Charlotte Department of Transportation

Memorandum

Subject: Rezoning Petition 08-042: Located between West Tyvola Road,
Yorkmont Road and Billy Graham Parkway

REZONING PLAN TECHNICAL DATA SHEET
 FOR PUBLIC HEARING PETITION #: 2008-042

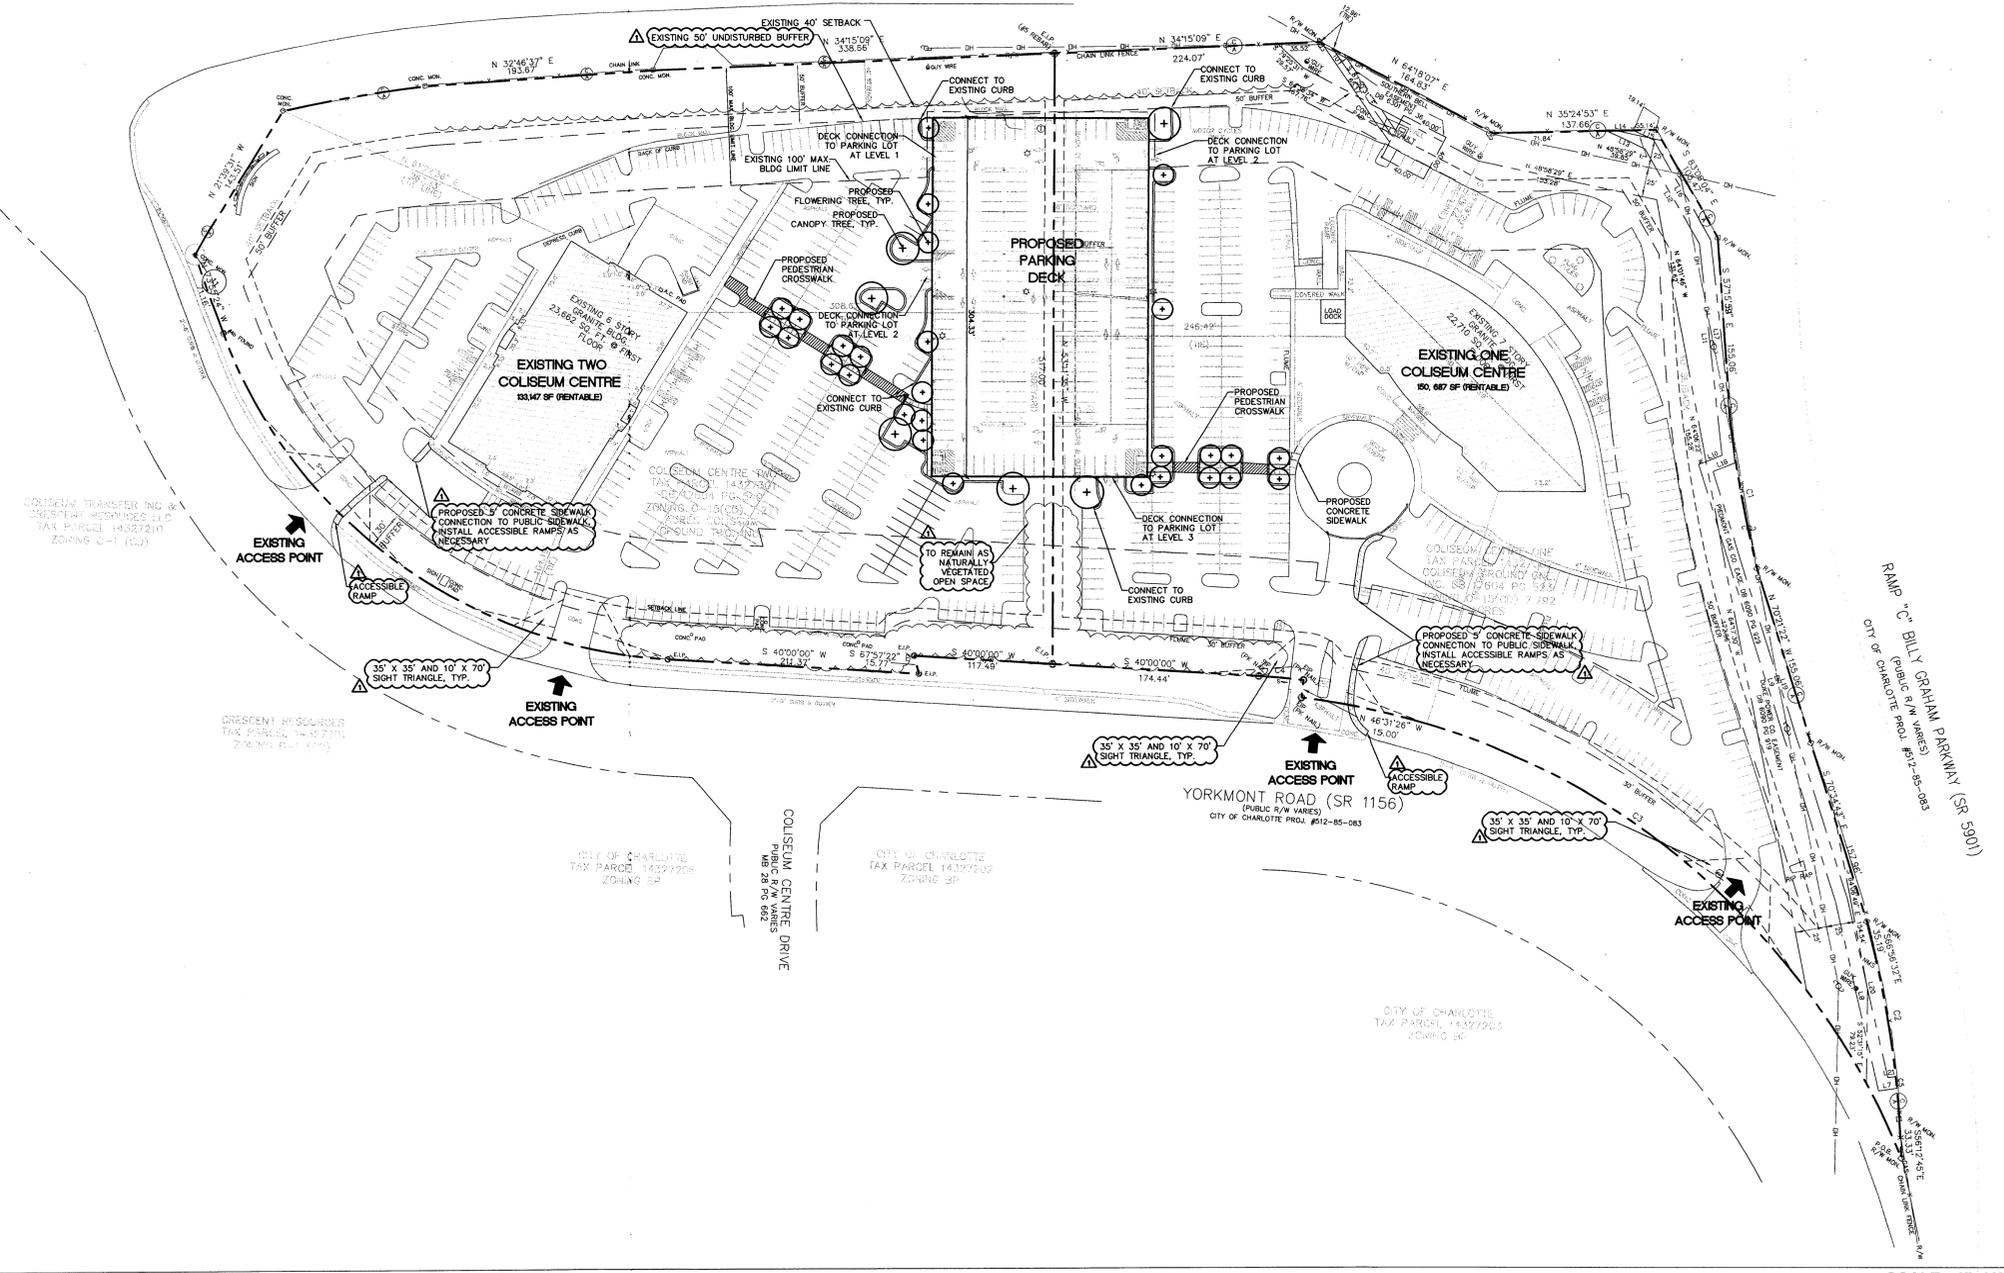
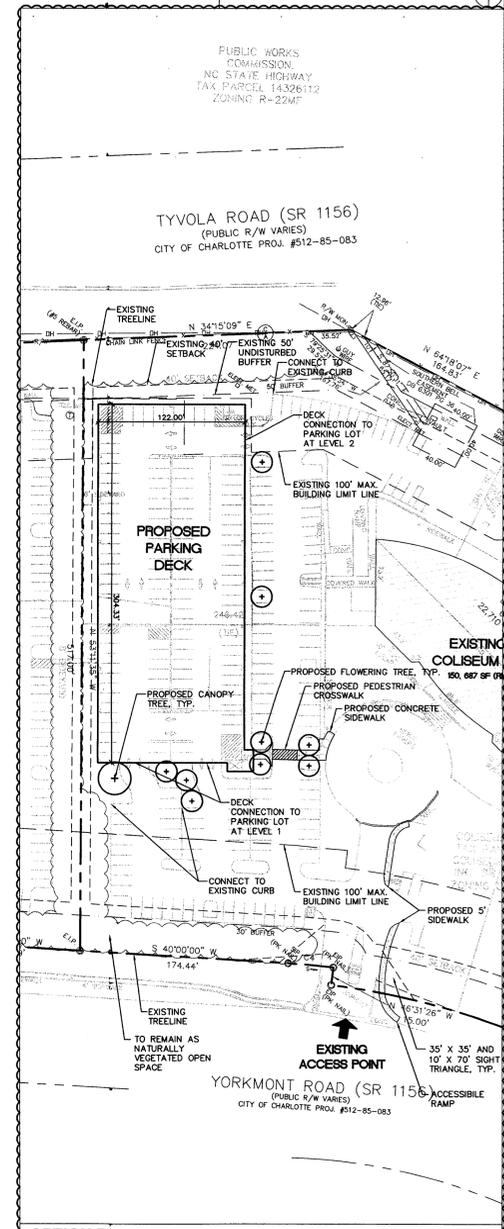
1. The site plan needs to provide an internal system of 5-foot or wider sidewalks that connect building entrances to sidewalks along Yorkmont Road and the existing sidewalk on Yorkmont Road needs to be extended to the Billy Graham Parkway controlled access fence.
2. The NCDOT State Route or Highway number needs to be labeled for each Billy Graham Parkway and for Yorkmont Road.

**REZONING PLAN
TECHNICAL DATA
SHEET**

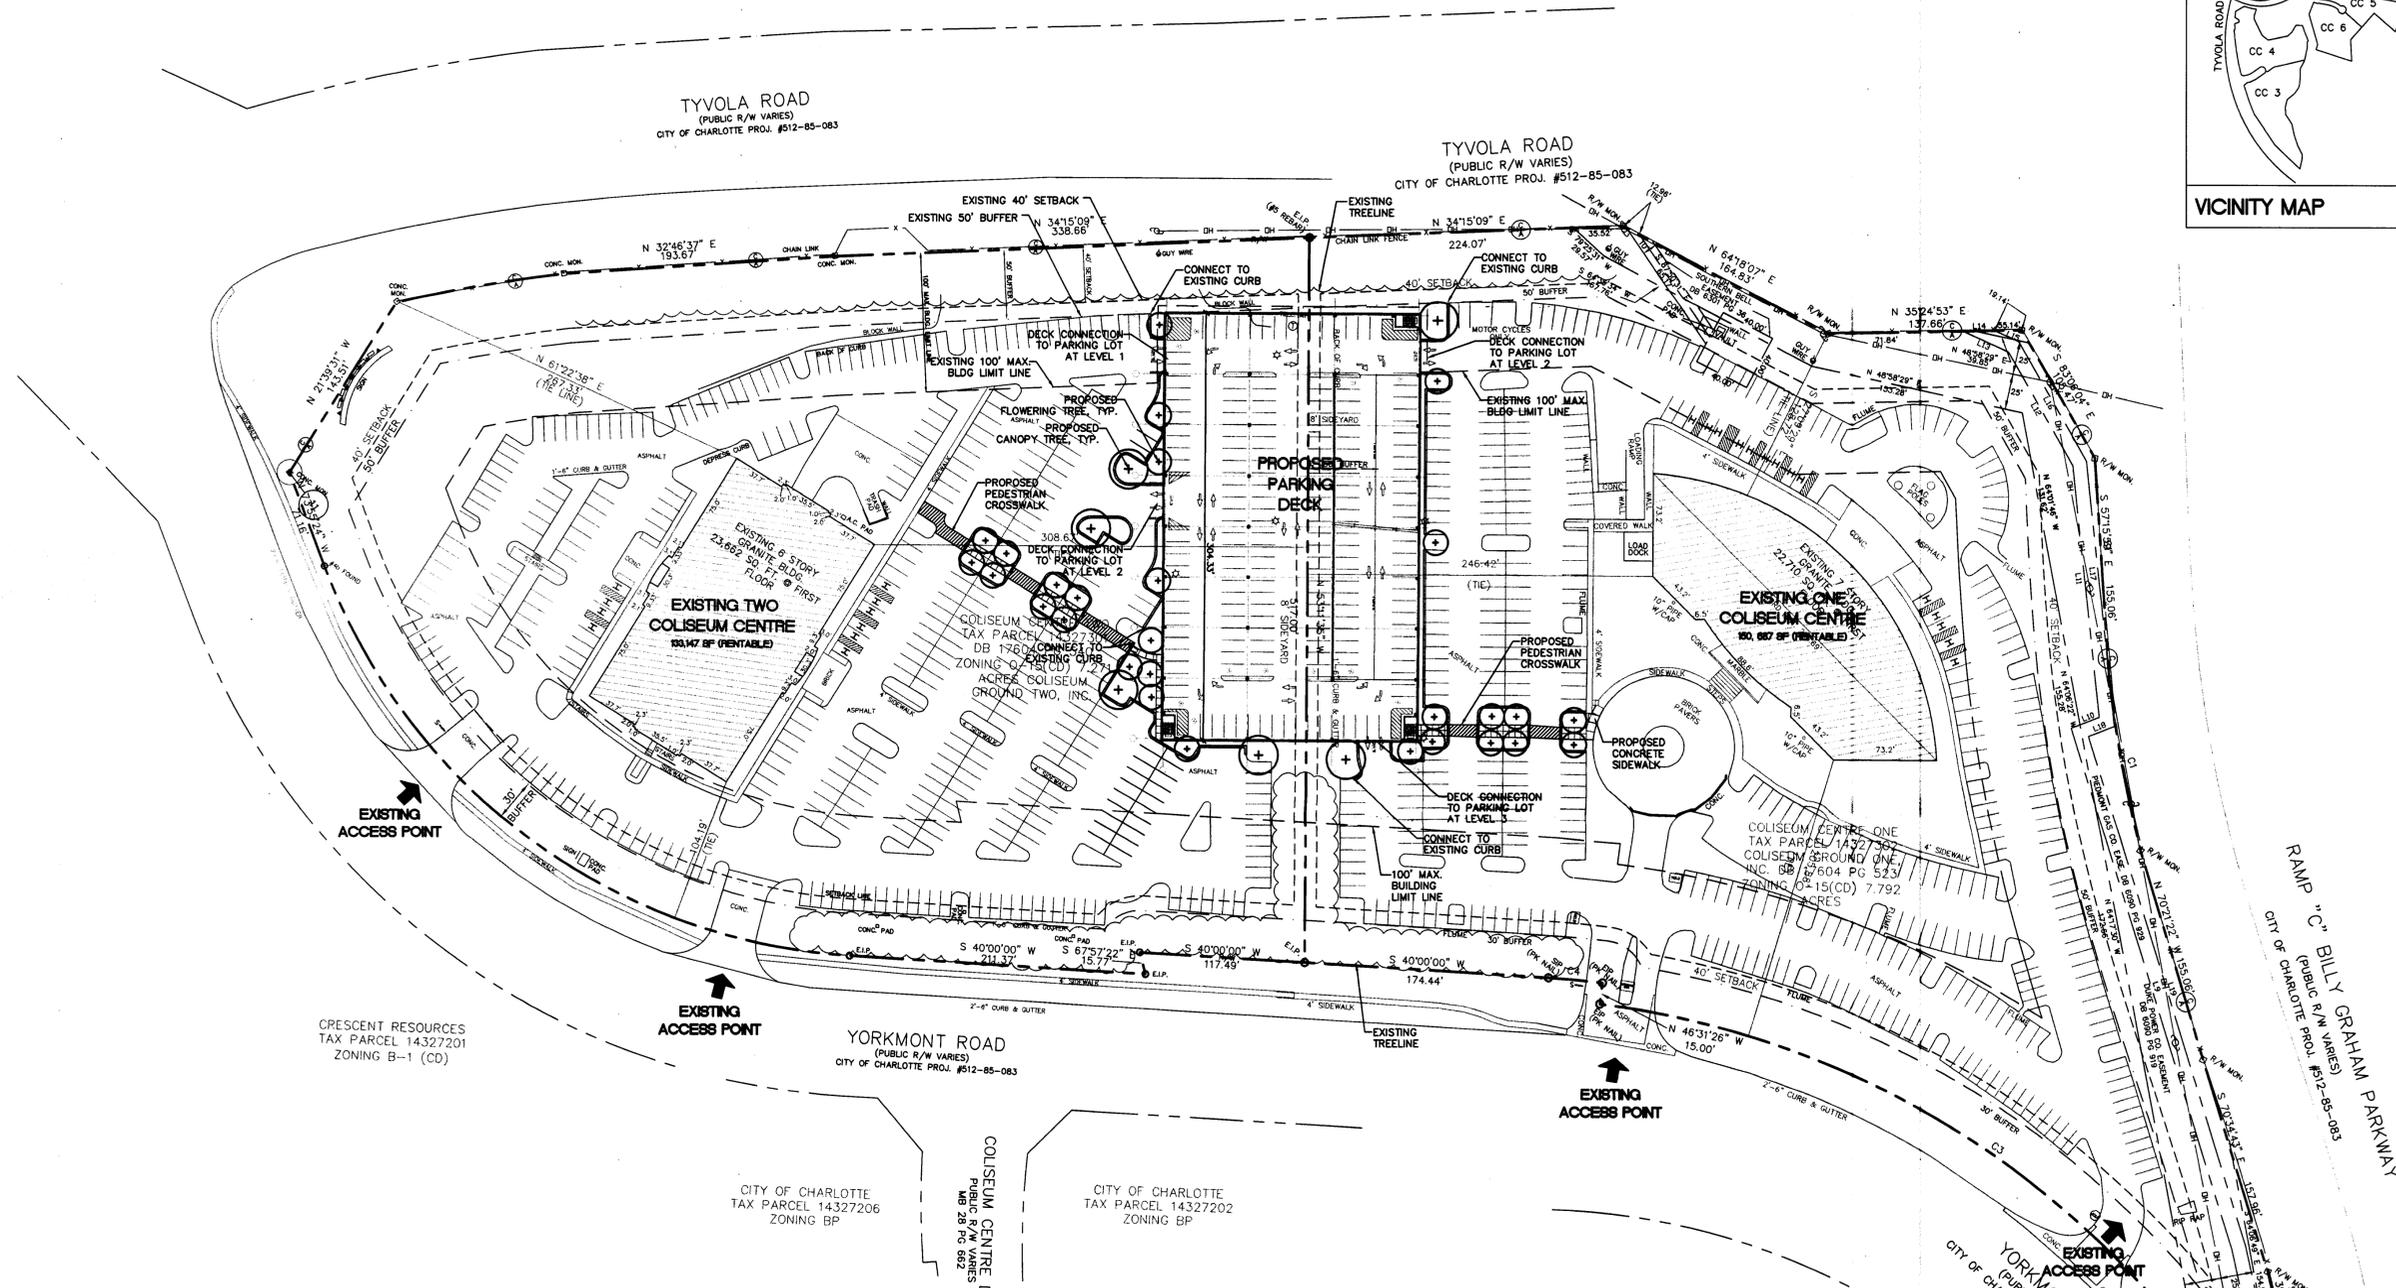
Adequate sight triangles must be reserved at the existing/proposed street entrance(s). Two 35' x 35' and two 10' x 70' sight triangles are required for the entrance(s) to meet requirements. All proposed trees, berms, walls, fences, and/or identification signs must not interfere with sight distance at the entrance(s). Such items should be identified on the site plan.

- Dimension width of the existing and proposed driveways.
- New/reconstructed driveways must be drop curb ramp Type II driveways.
- Indicate the locations and widths of all adjacent and opposing driveways.
- Indicate typical parking module dimensions.
- Include a parking summary with figures for the numbers of parking spaces required and provided.
